Monday 6th June 2016

REF No: 6/2016/0616/Full.

Having seen the proposed changes to Number 2 Dehavilland Close,

PROPOSED SITE LAYOUT

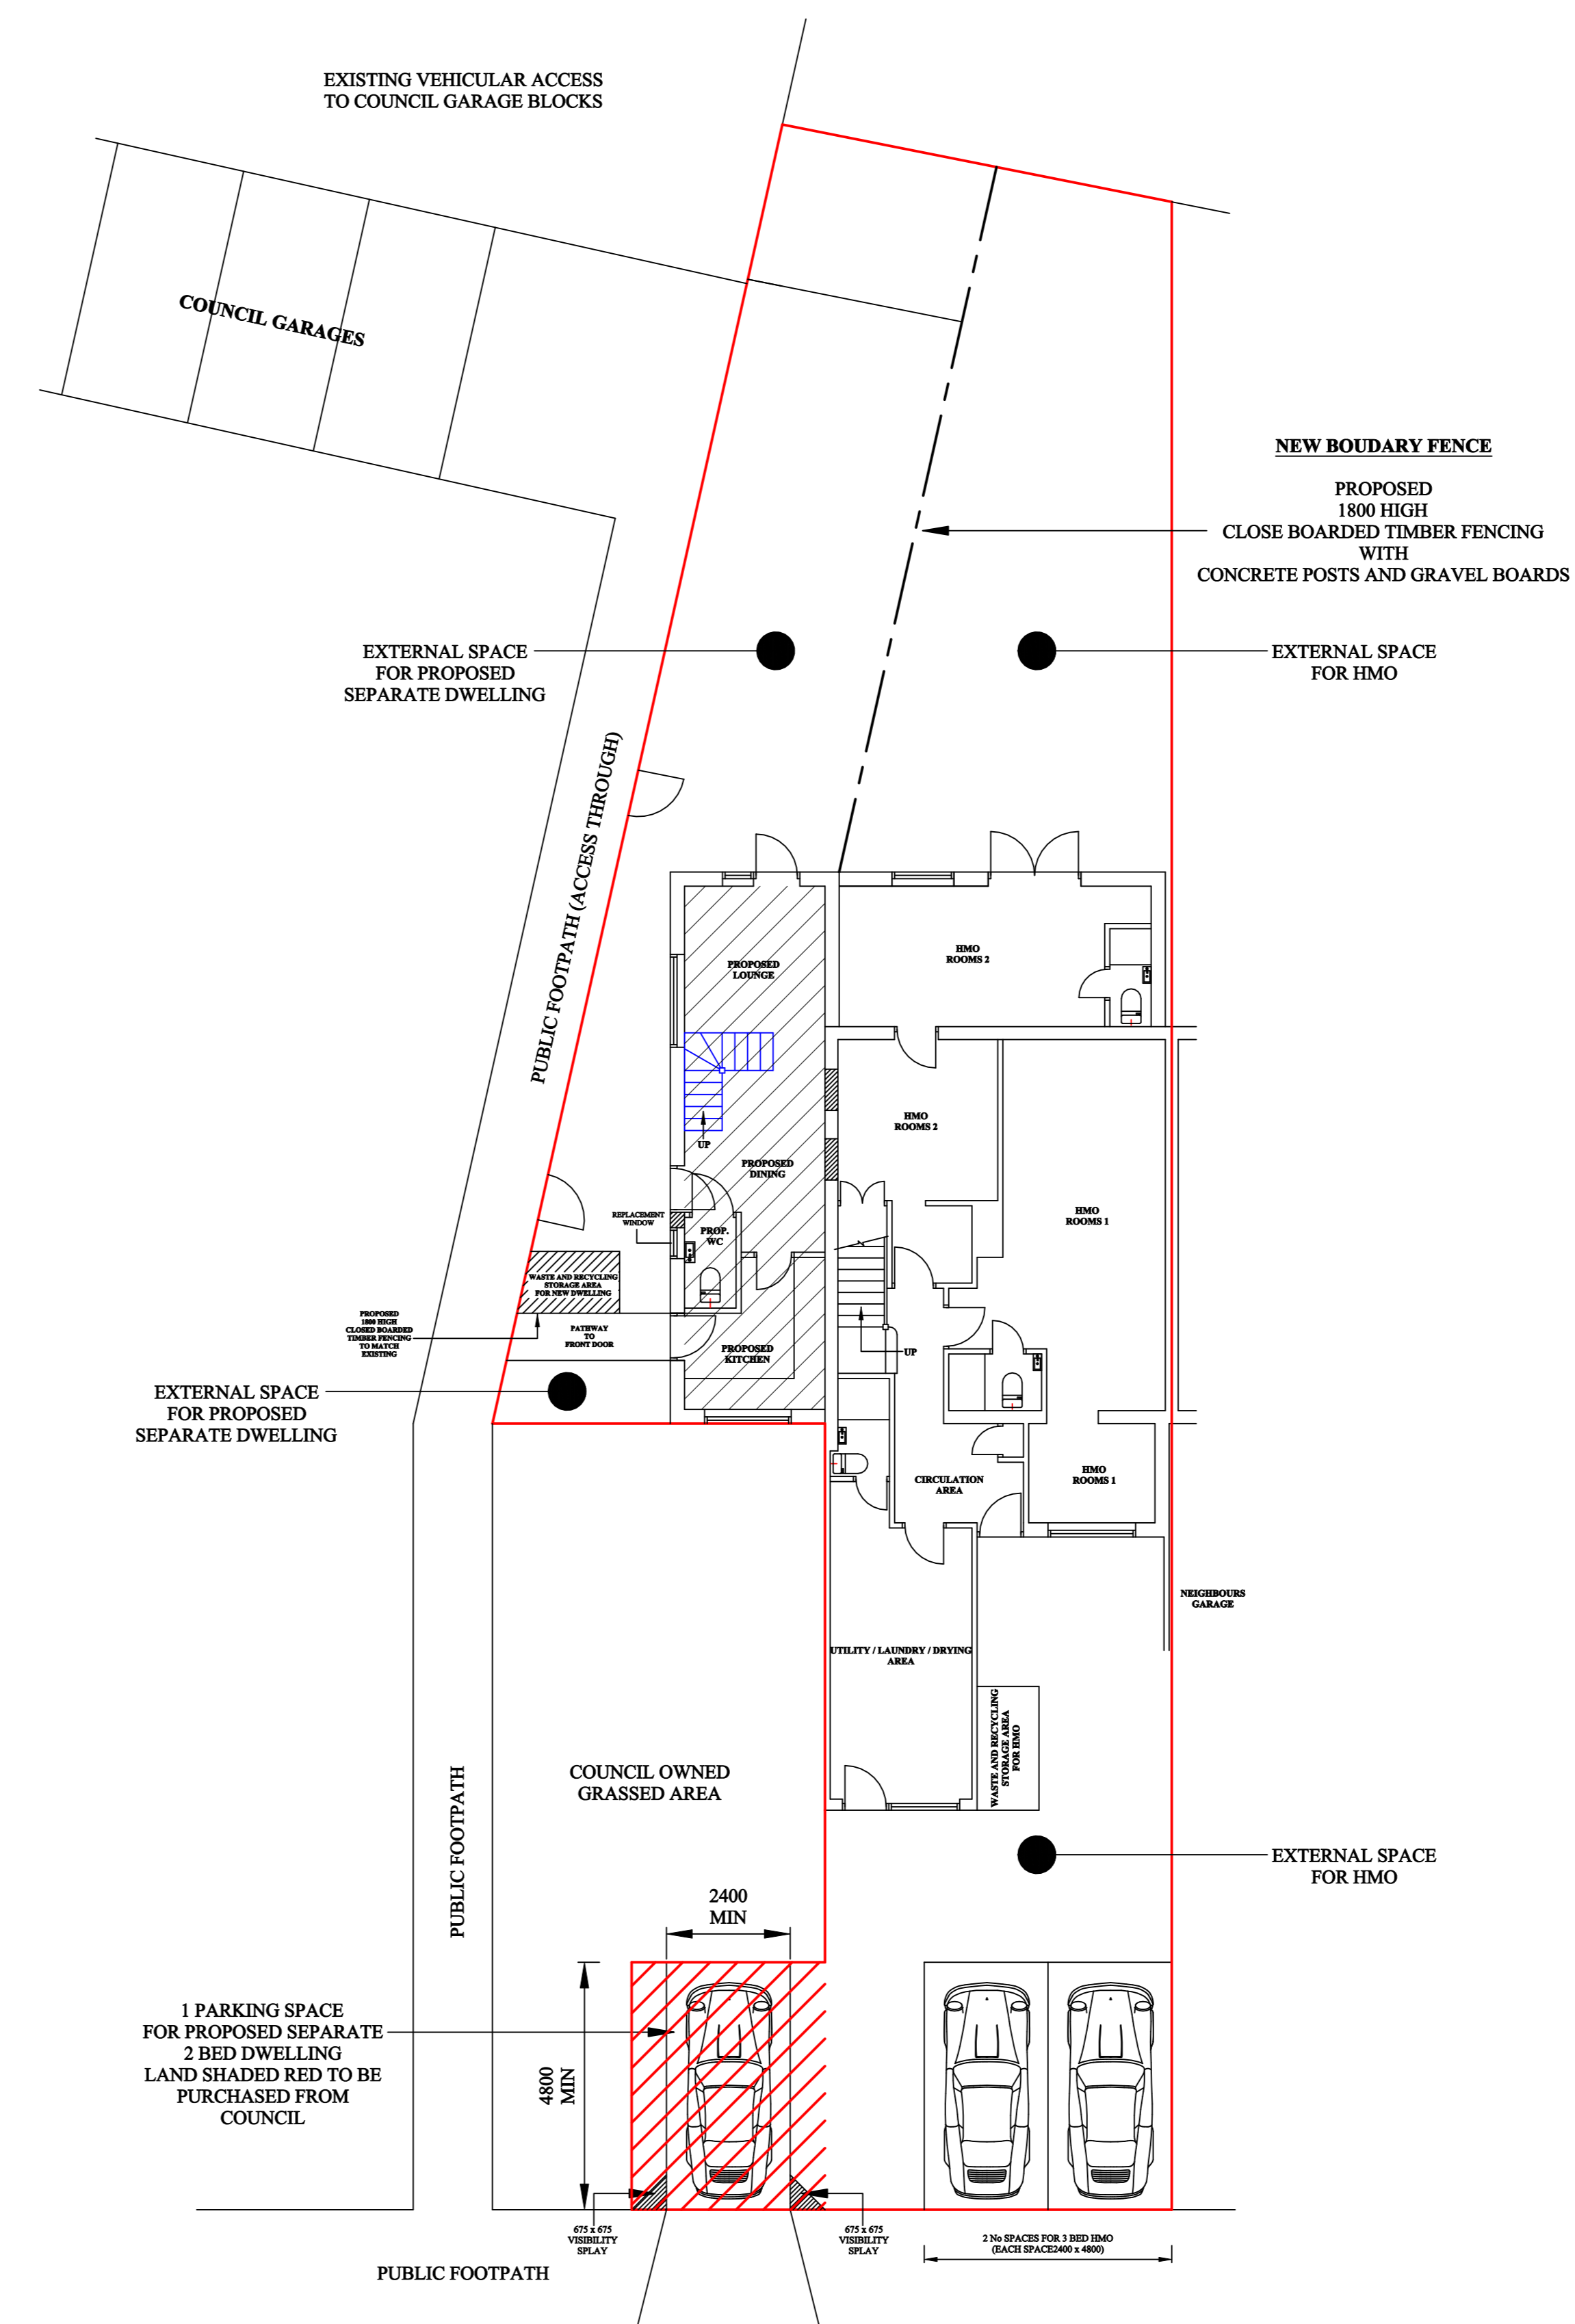
I am opposing the plans submitted to WtH Council because it will intrude on my privacy to the rear of the premises, also, having parking facilities within a quiet garden area will cause noise and pollution and also affect security issues to my mid Terrace property. I do not object to the conversion of the dwelling inside, simply the parking issues to the rear of the

house as proposed, could not a small proportion of the "Council owned grassed area" be purchased and converted to keep all vehicles to the front aspect of the property
